Senior Living Facility

Administrative Amendment Request

Project #PR- 2018-001584

SI-2018-000151

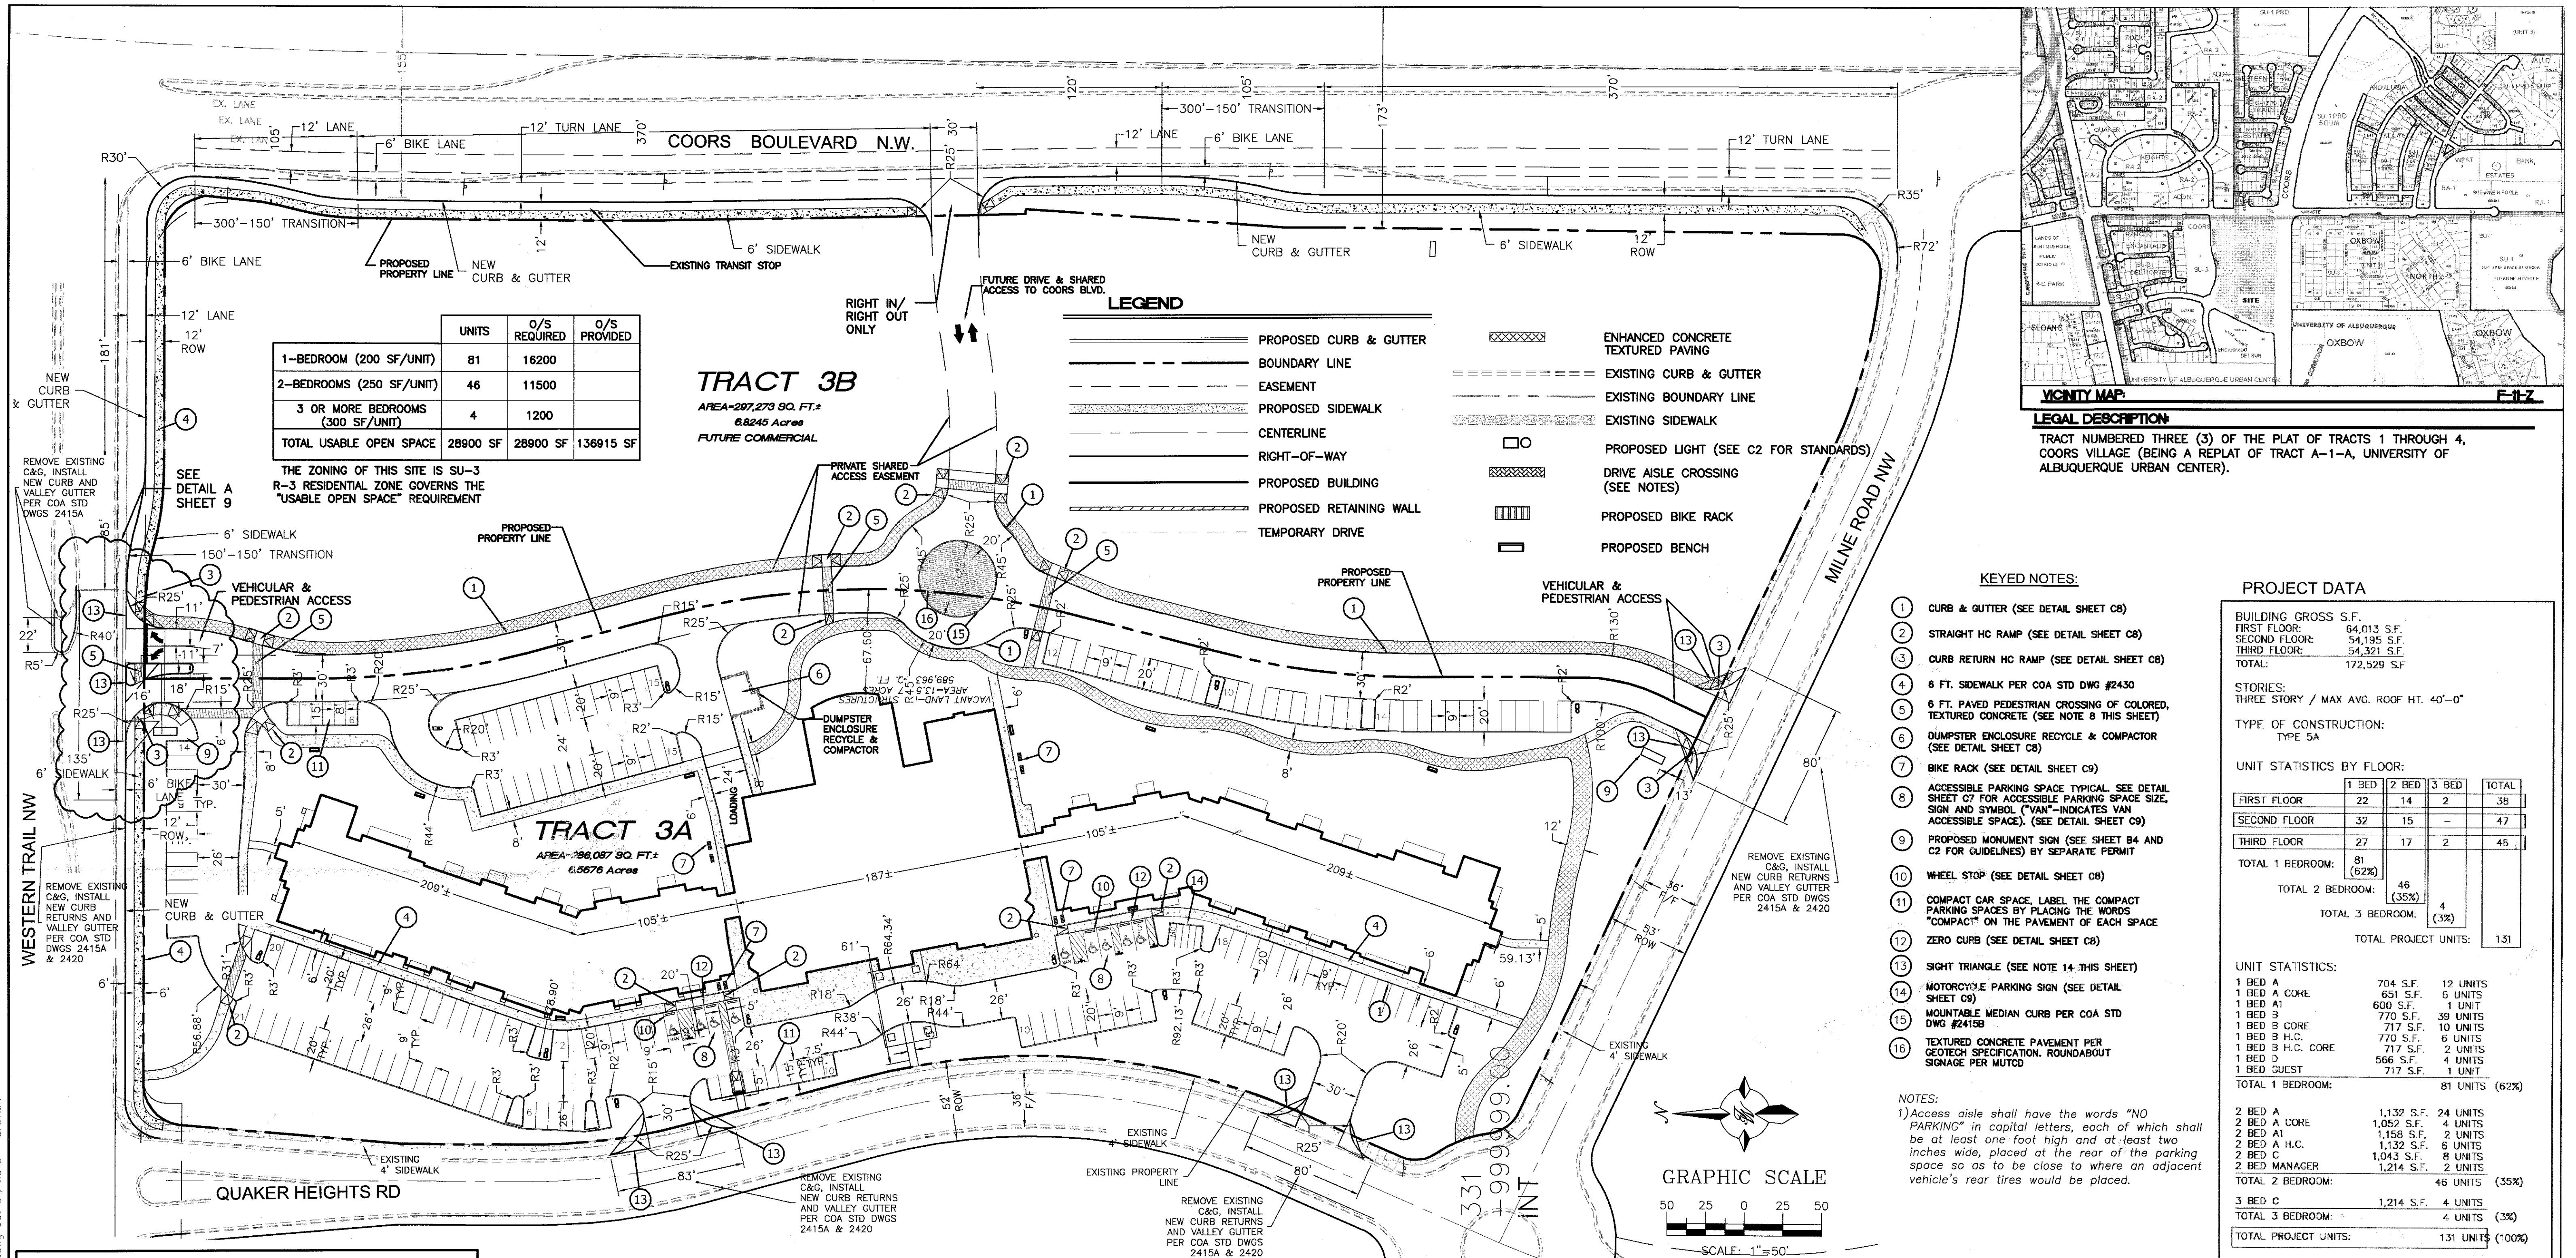
1. The proposed roundabout to the east of the site was eliminated from the original site plan. Since this is a significant change to the roadway pattern, please show all roadway facilities within this area on the site plan. How does this affect infrastructure requirements?

TW Response: There are no changes to the infrastructure requirements. The traffic circle was removed and approved by DRB on 3/6/19 PR-2018-001584 on the site plan for subdivision. Attached to this response is the approved plan on Exhibit A and Exhibit B detailing the connectivity and street sections for all roadways within the area on the site plan.
2. Refer to the IDO for the MX zone for sidewalk width requirements based on building square footage. Adjust accordingly.

ENGINEER'S SEAL	131 UNIT SENIOR INDEPENDENT LIVING COORS AND MILNE SITE PLAN FOR BUILDING PERMIT, TRACT 3A	DRAWN BY BUF
		DATE 02/16/18
		2017017-098
		SHEET # C3
		JOB # 2017107

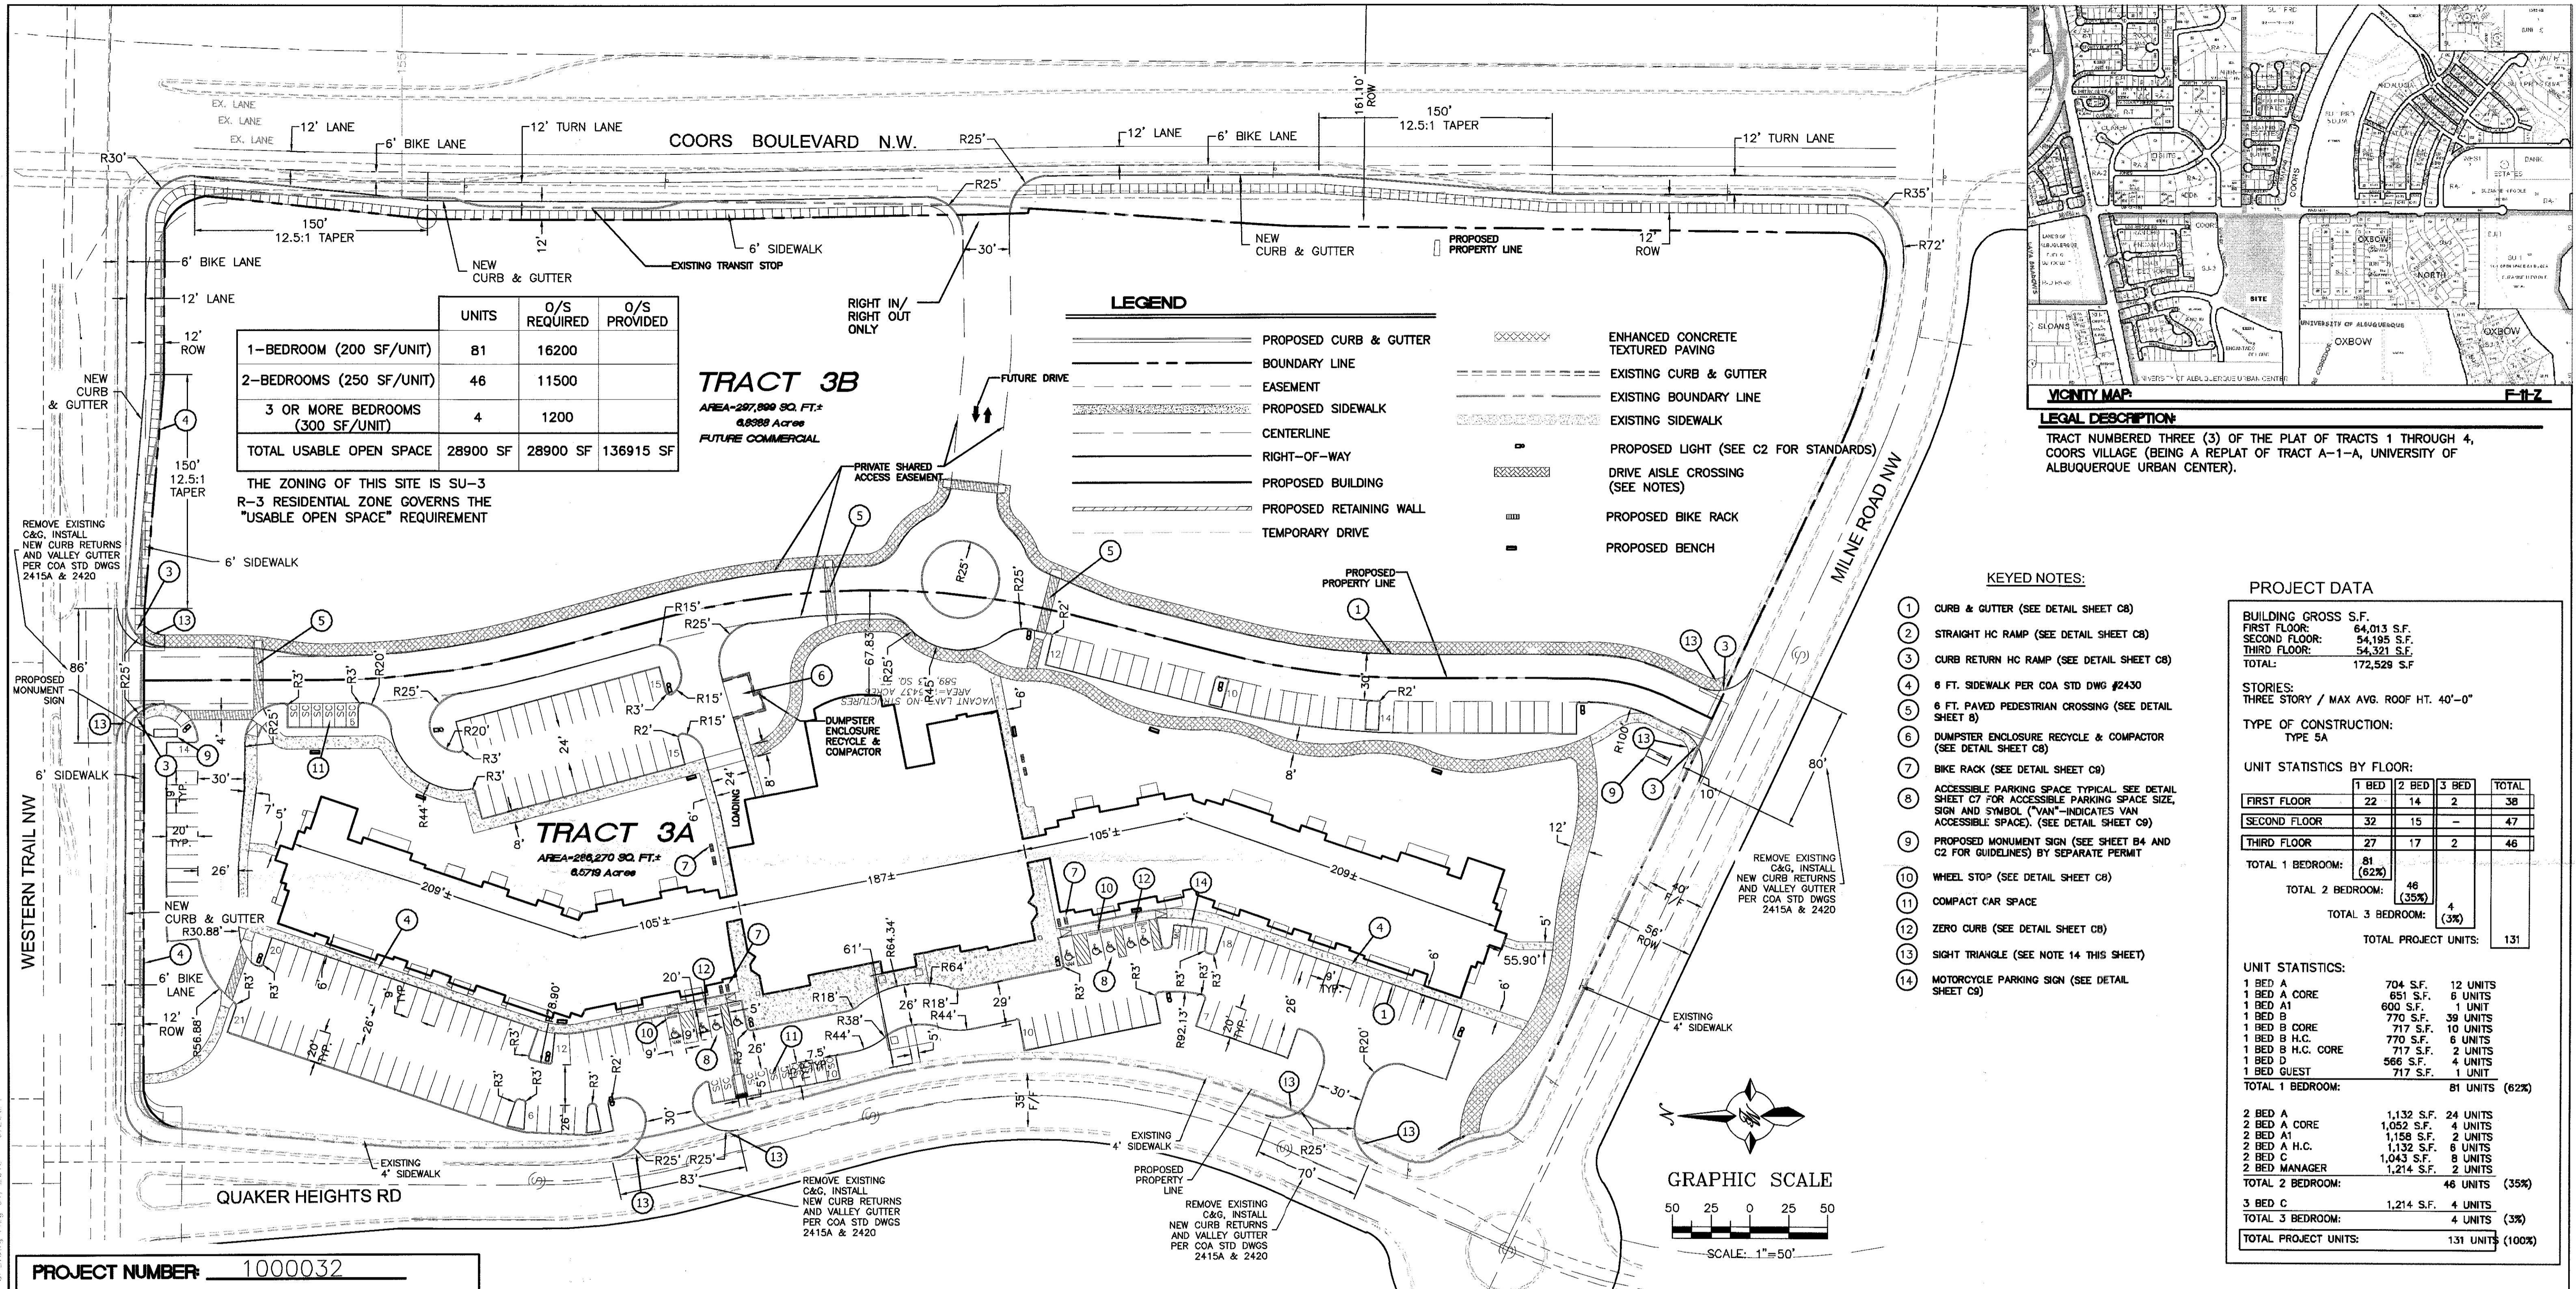
TW Response: No ramps are proposed and it will be a continuous header curb along the traffic-circle.
6. For the traffic circle west of the building, provide dimensioning of the asphalt drives and any one-way signage and directional arrows as applicable. Provide curb radii for the center island.

TW Response: Directional arrows were added to delineate the traffic flow direction. Curb radii and dimensioning were added to the asphalt drives, refer Sheet C1.
